Sunnica: Schedule of Changes to Framework CTMP and Travel Plan.

Hedge Height
2-4m

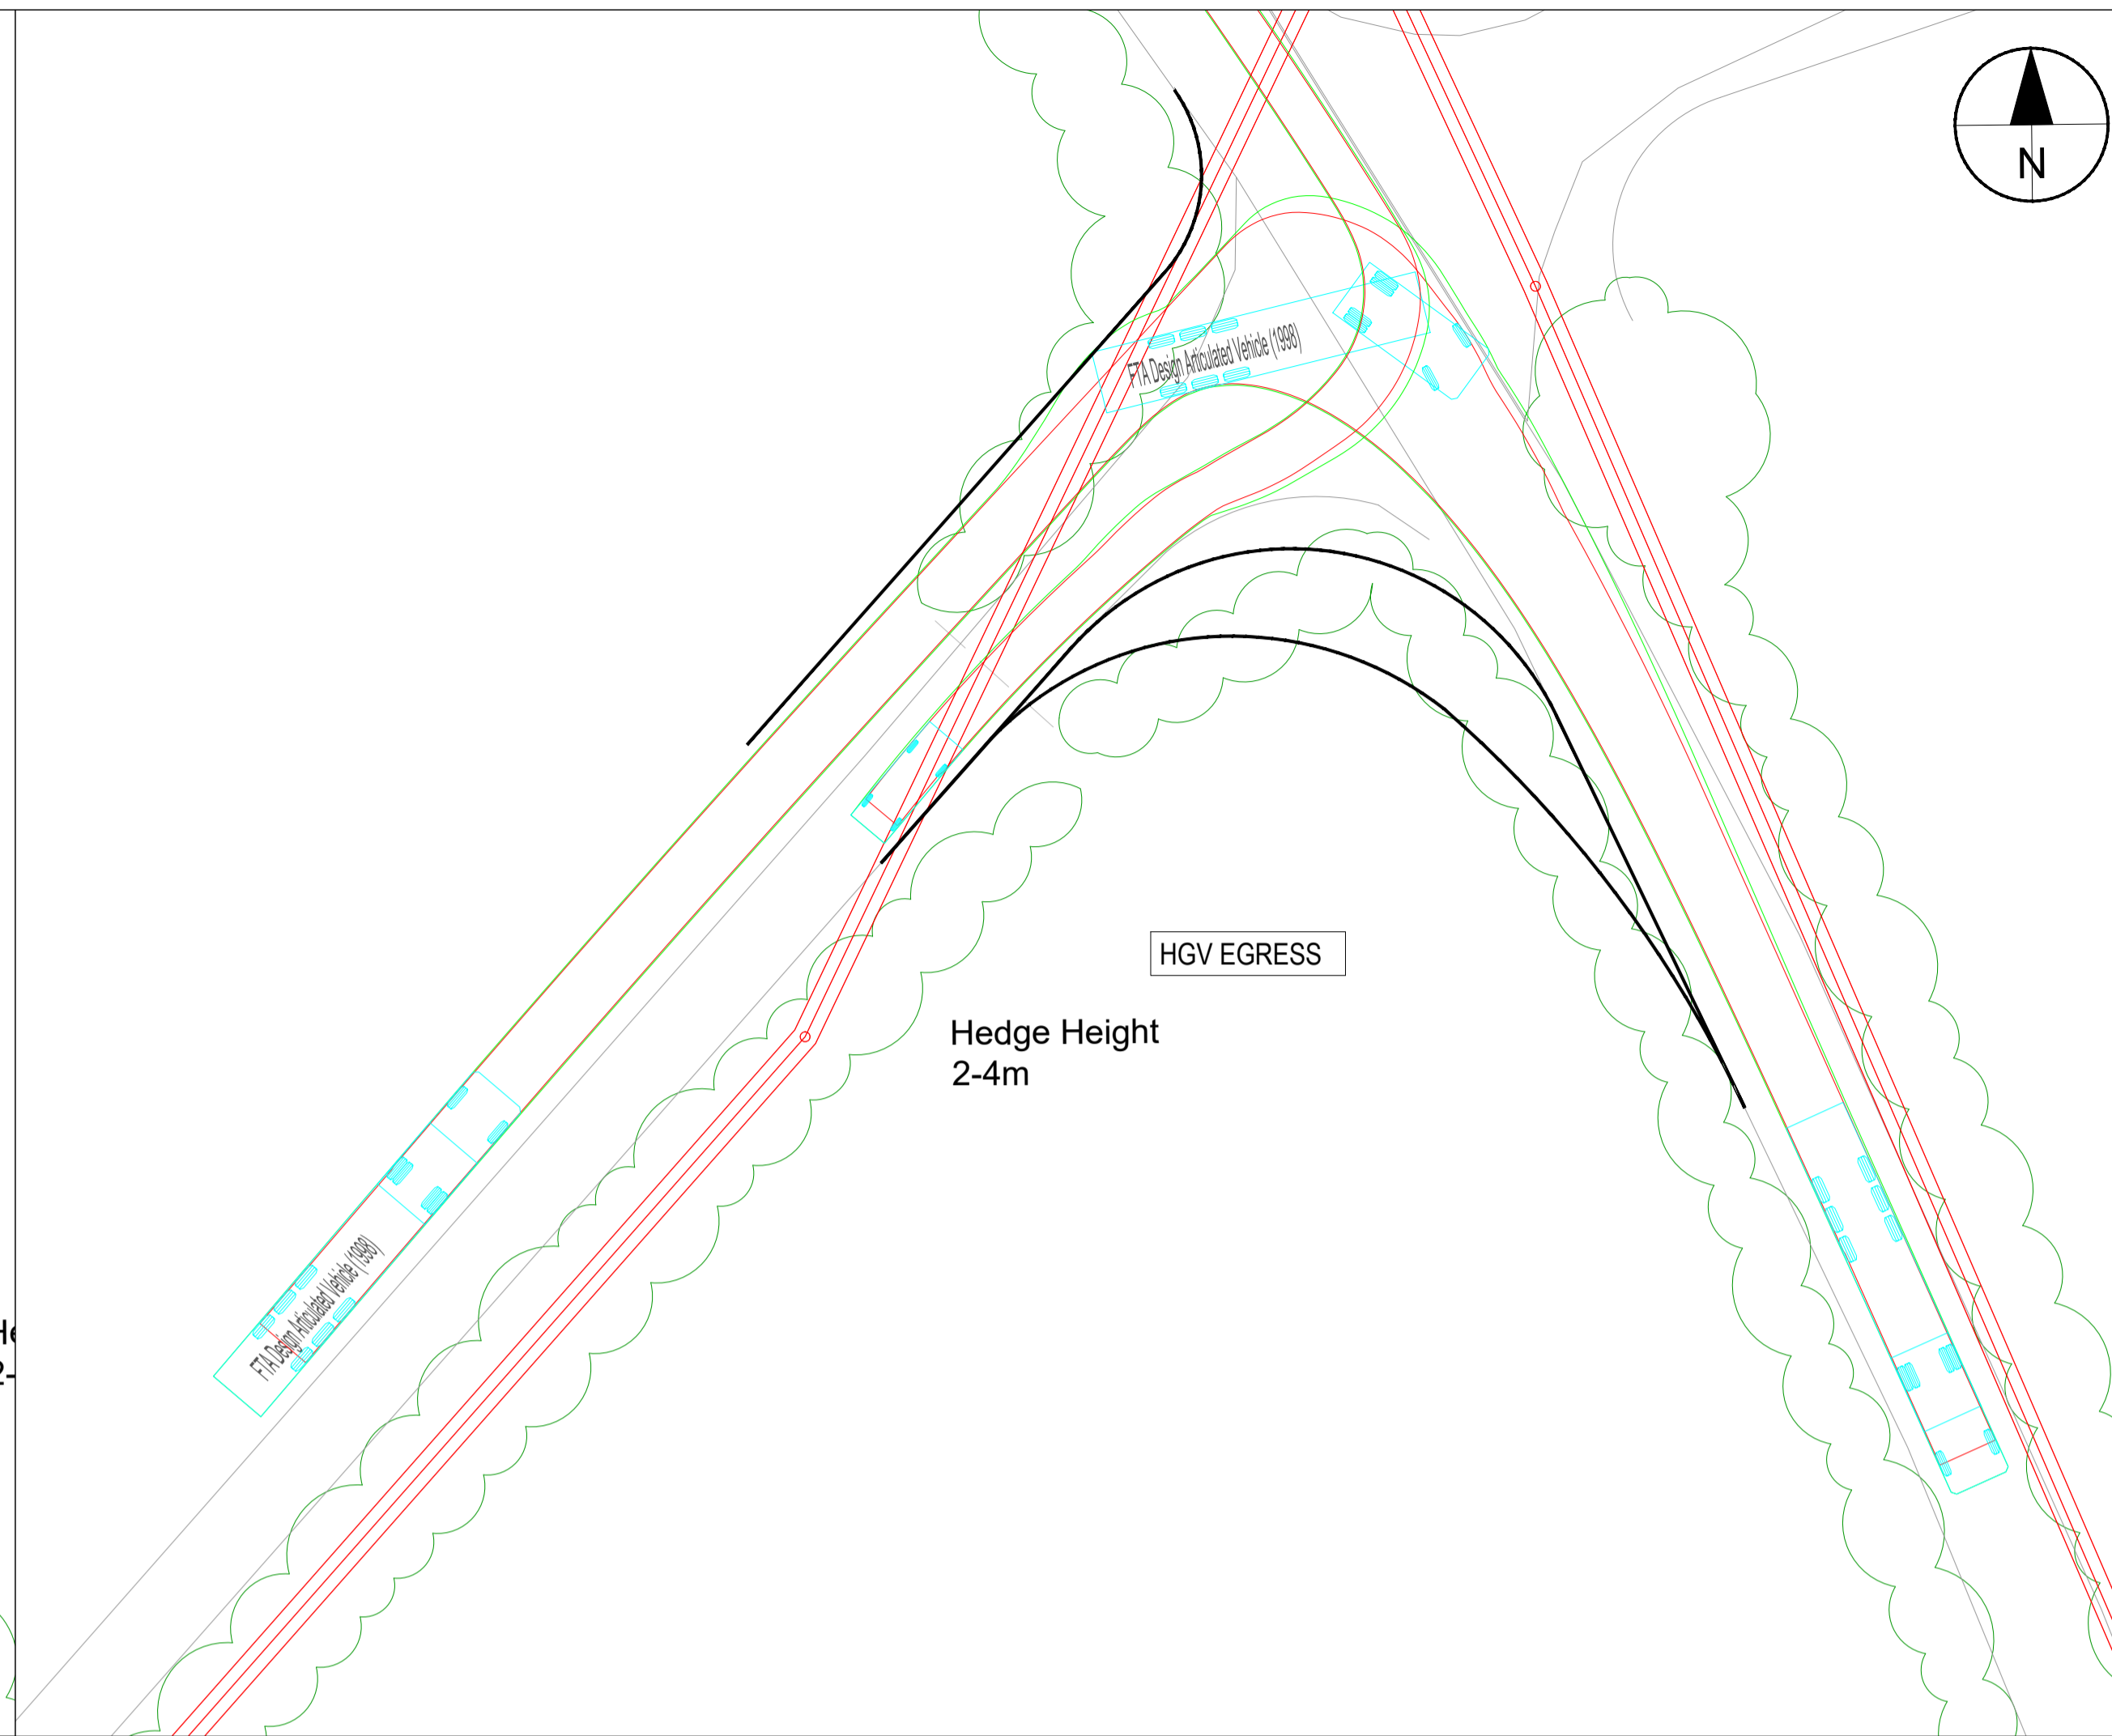
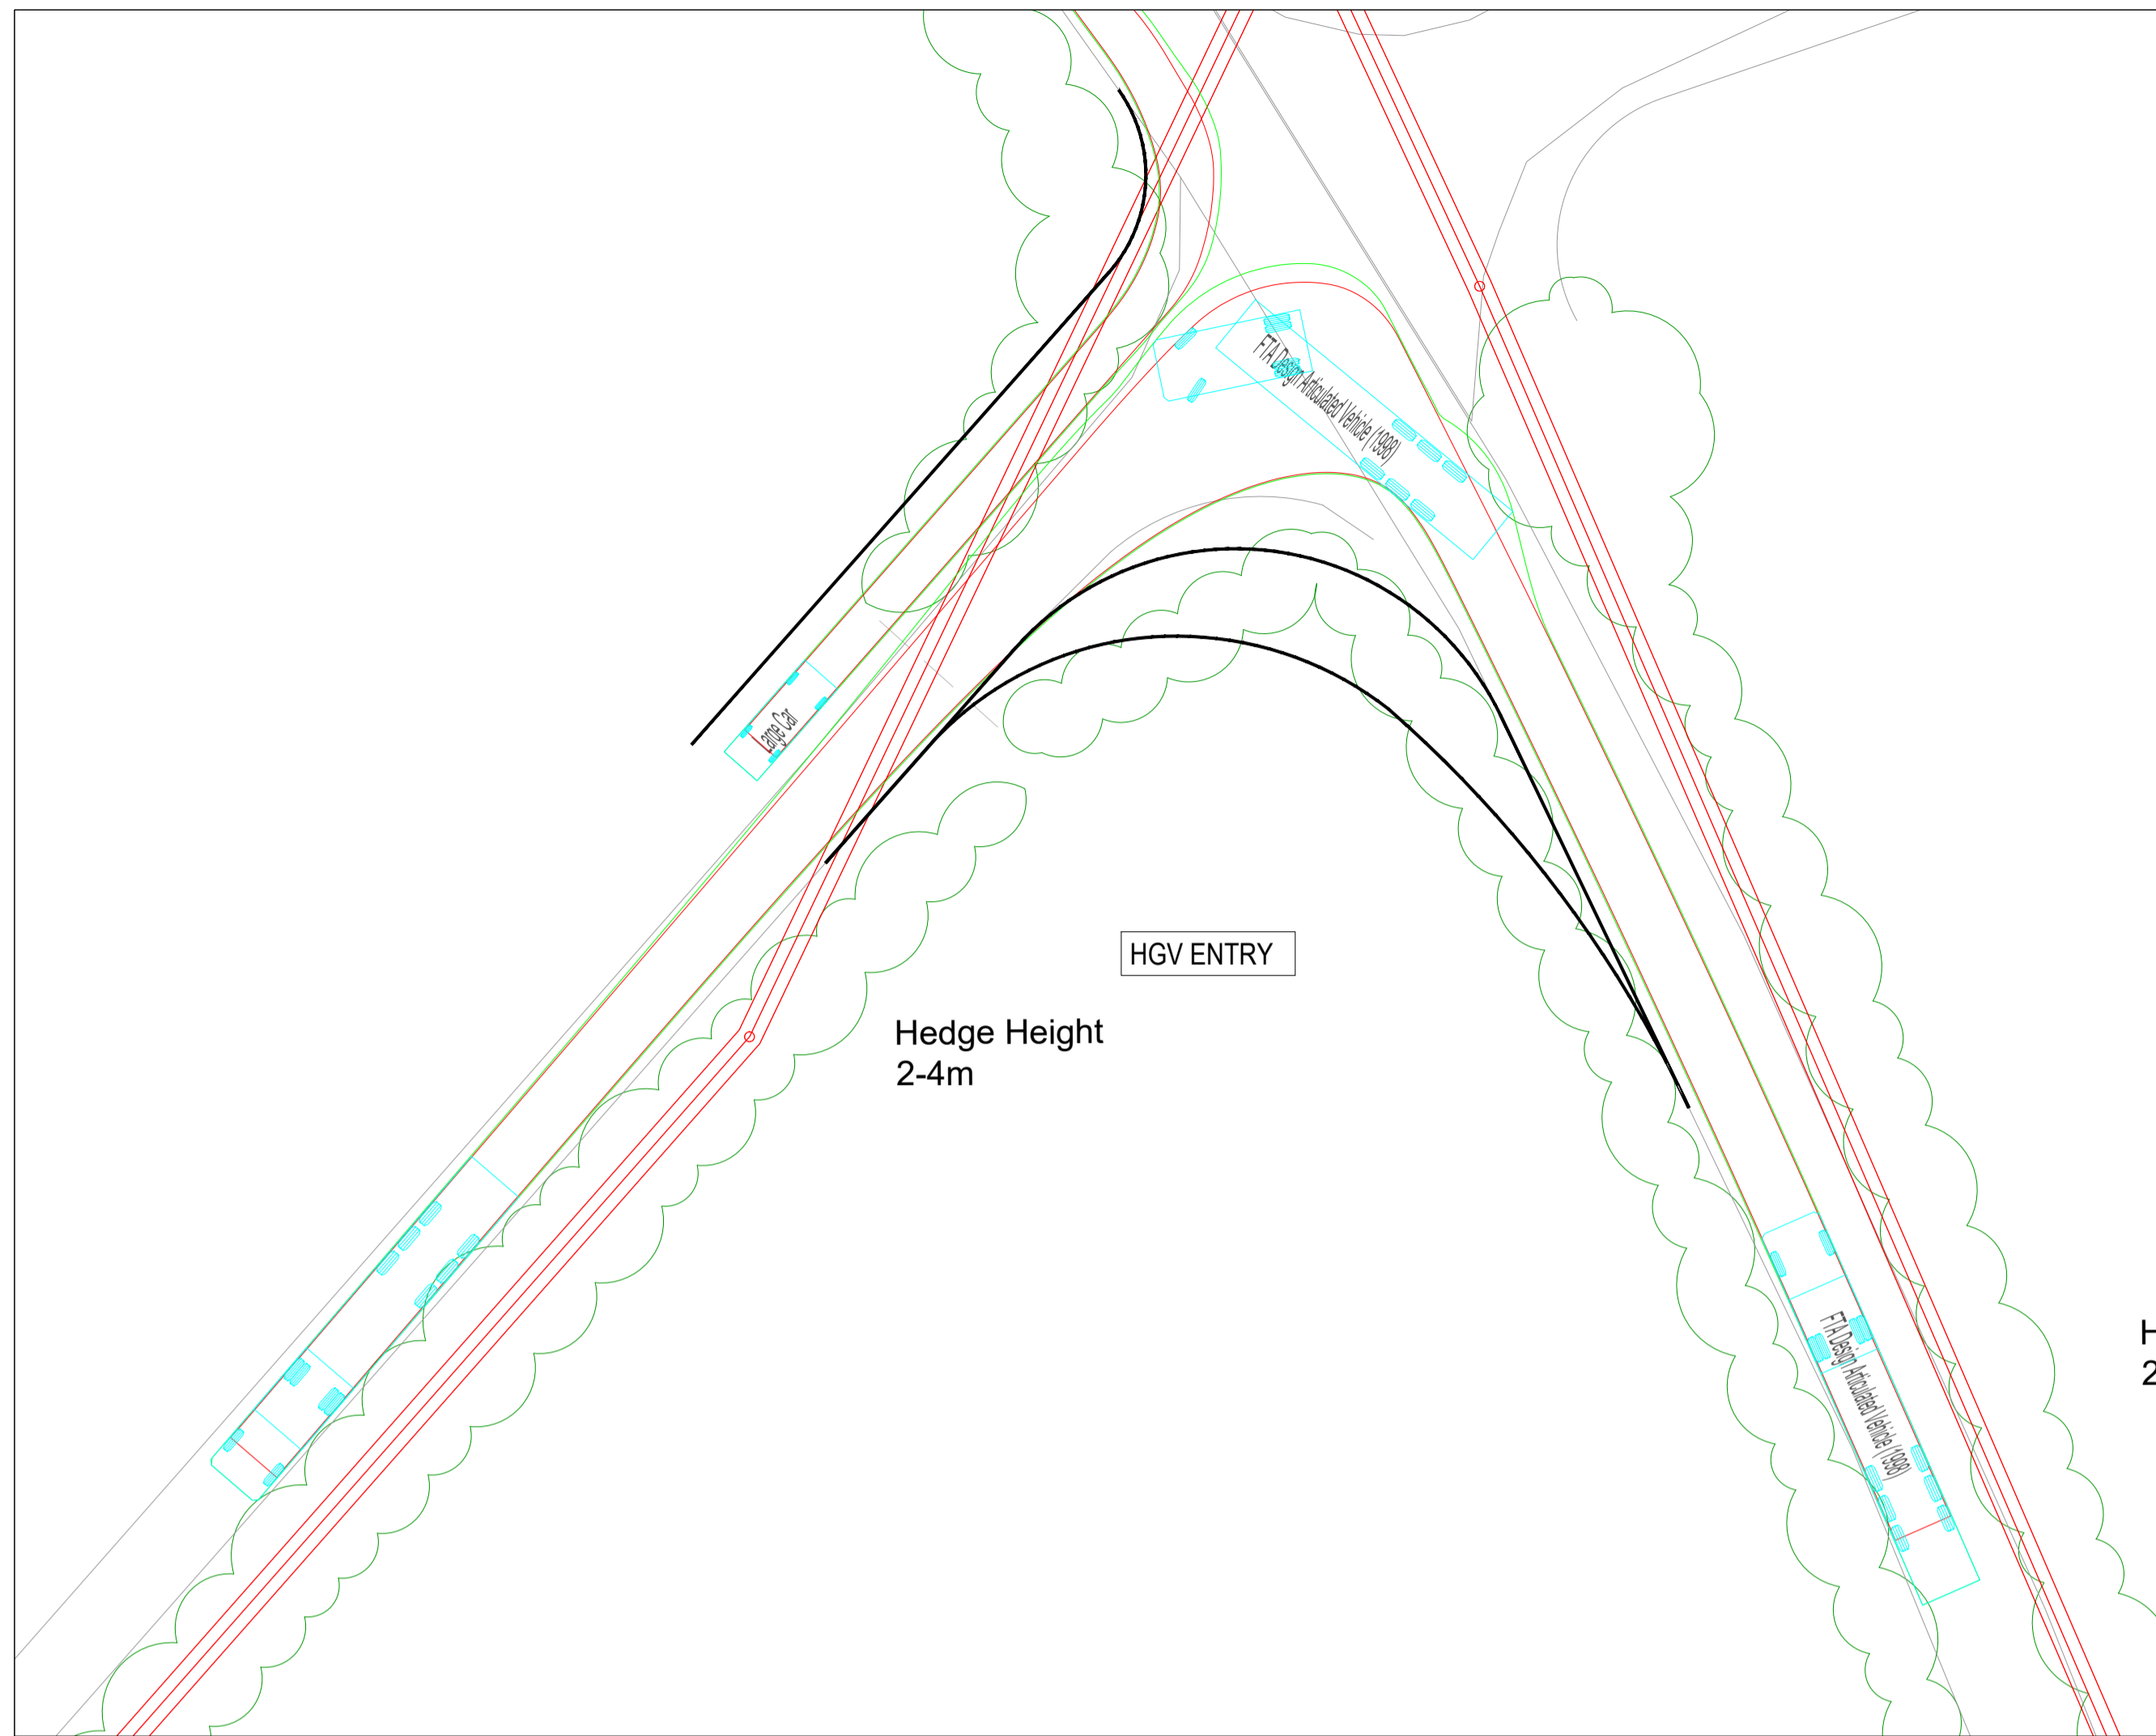
| Ref | Issue | Change |
|-----|--|--|
| 10 | Clarification regarding the site access layout during the construction and operational phase at the Sunnica West Site A: Site Access A on La Hogue Road. | <p>The Applicant will:</p> <ul style="list-style-type: none"> Provide clarification on the swept path analysis, visibility splay and the site layout during the construction phase Strengthen control measures set out in the CTMP and Travel Plan. |

| | | <ul style="list-style-type: none"> • Provided clarification on the swept path analysis, visibility splay and the site layout during the operational phase. |

CABLE ROUTE (CR-J) & (CR-K)
SITE ACCESS J & K
A142 / NEWMARKET ROAD

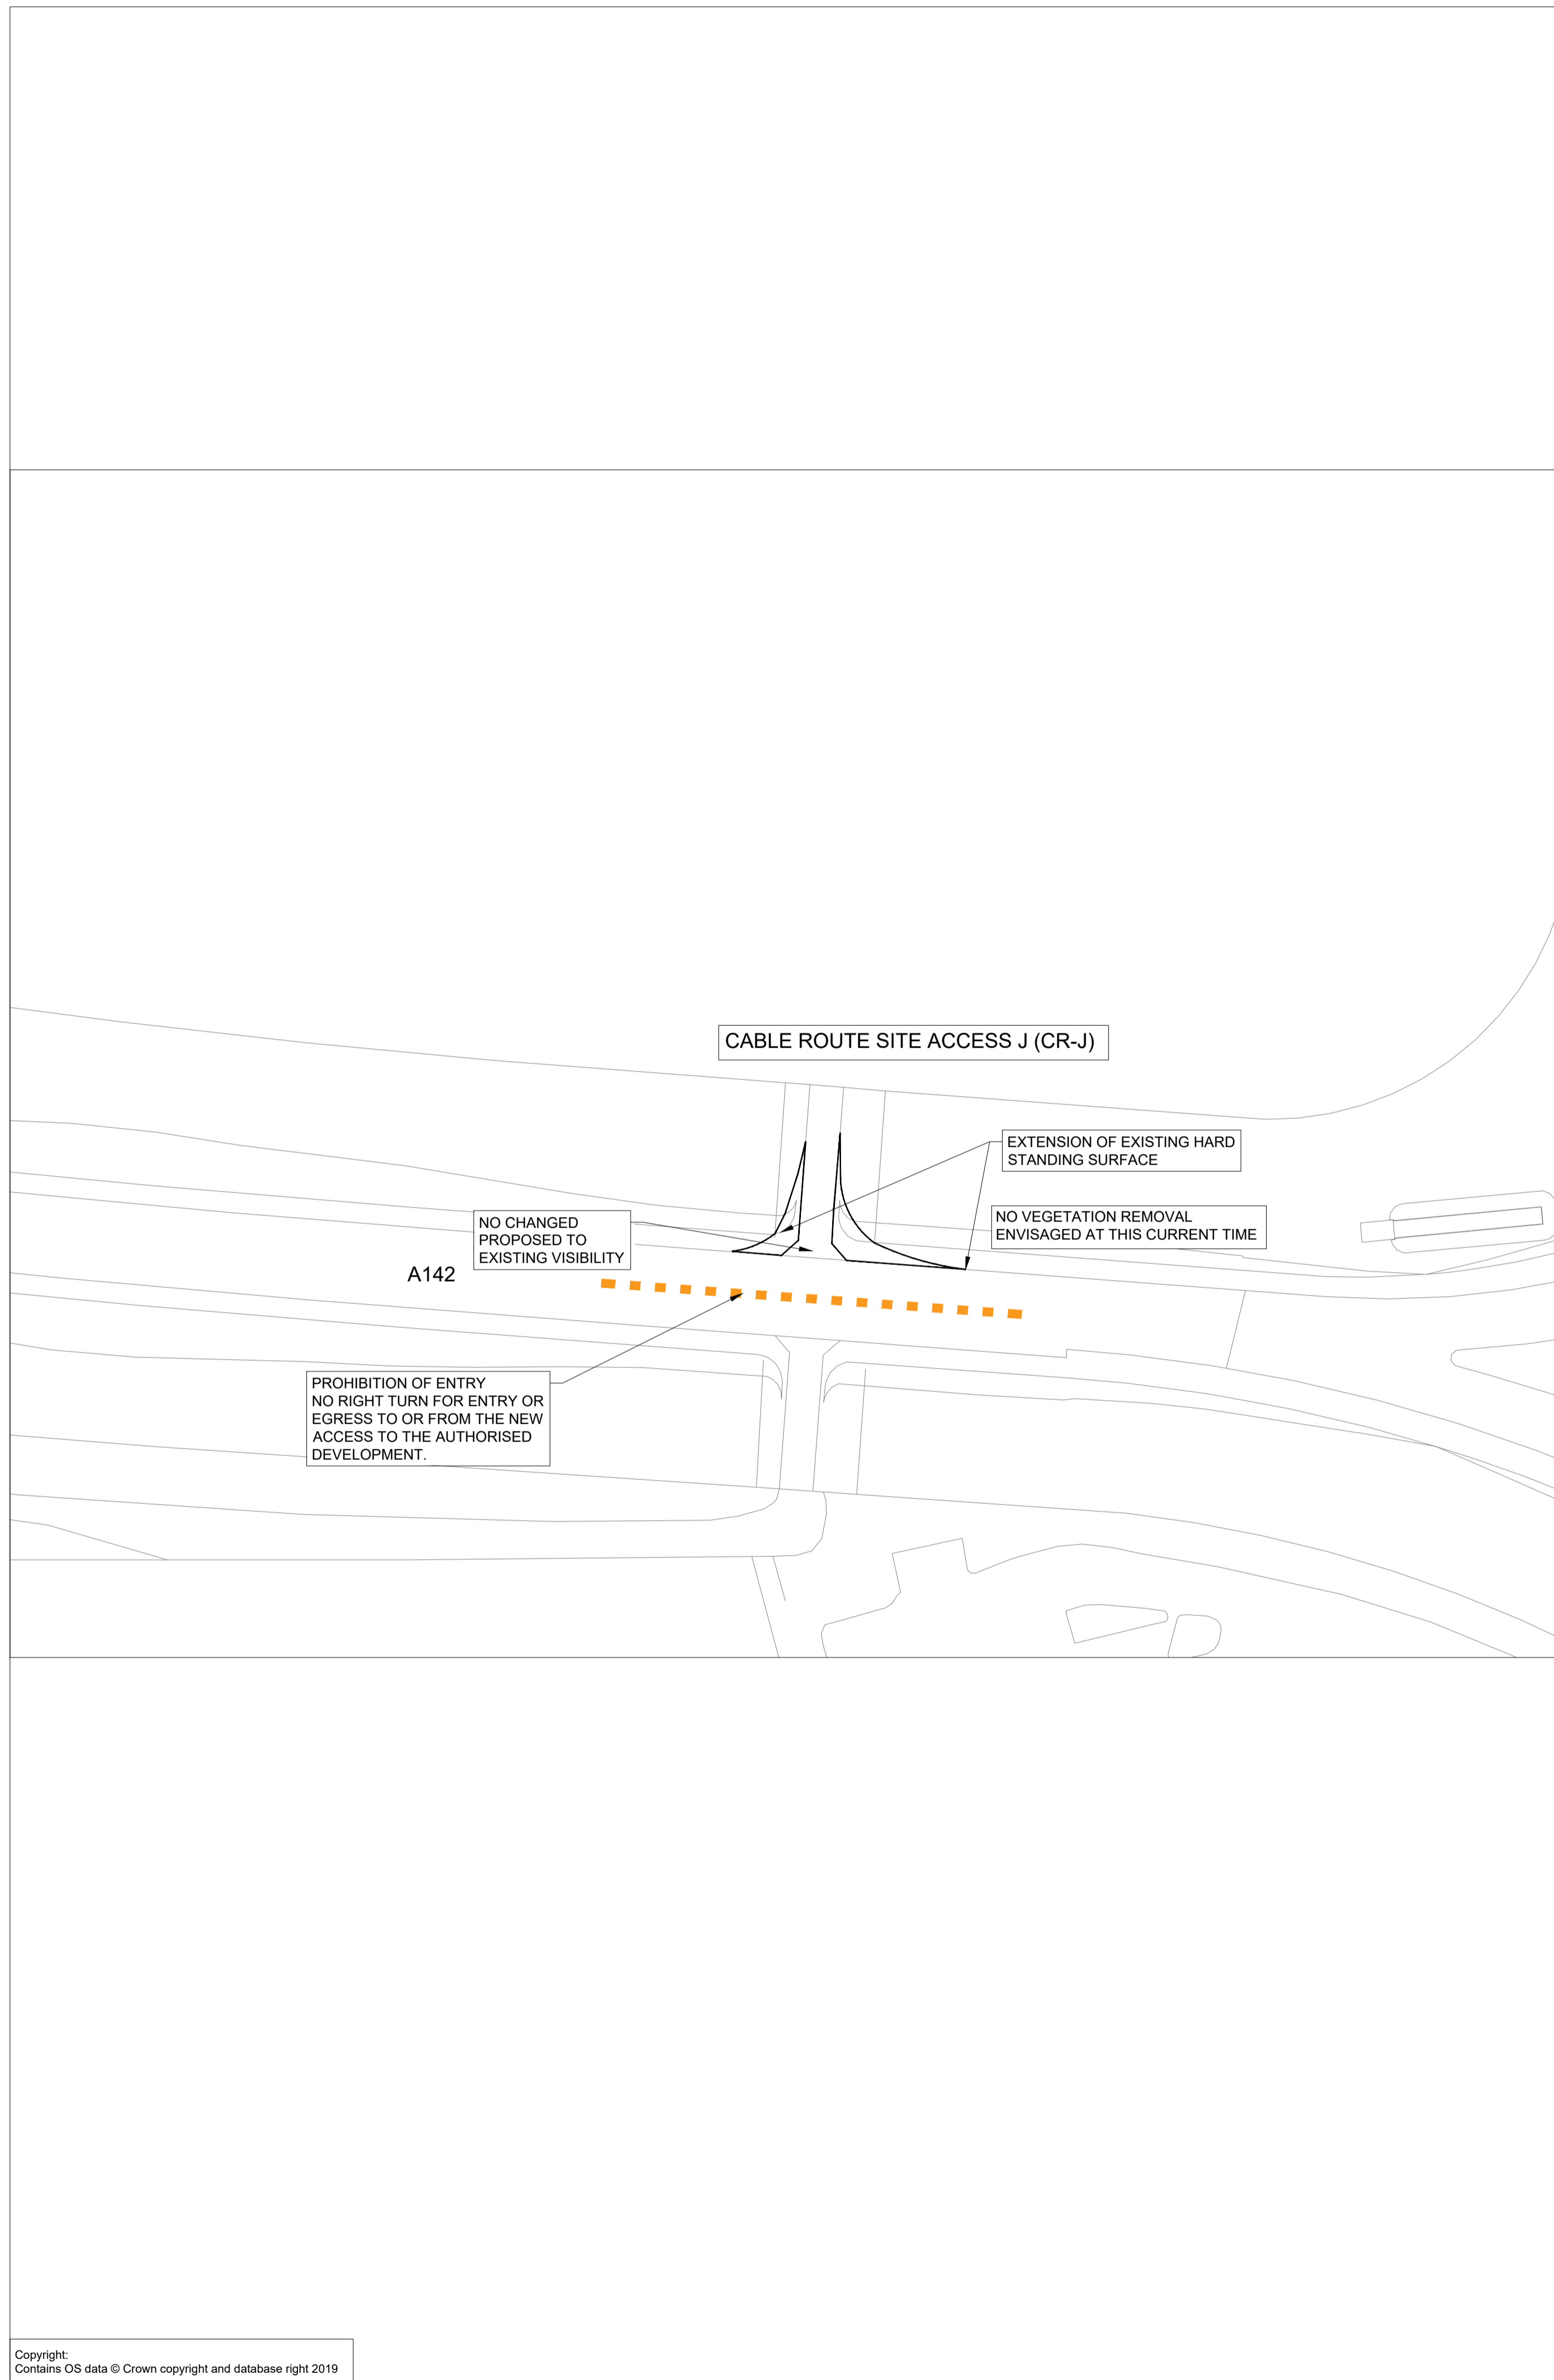
| 11 | Concerns at the A142 for Cable Route Site Access J on A142 and the swept path analysis shown crossing over onto the opposite side of the carriageway and the current site access arrangement, given the location to the A142 roundabout (circa 100m to the east), and the rear shunts with HGV turning into the site access | <p>The Applicant will:</p> <ul style="list-style-type: none"> • Provide a drawing to show additional space for the left turn movement and to demonstrate that the swept path of the HGV will not cross over onto the opposite side of the carriageway. • A RSA which will consider the rear shunts issue. |
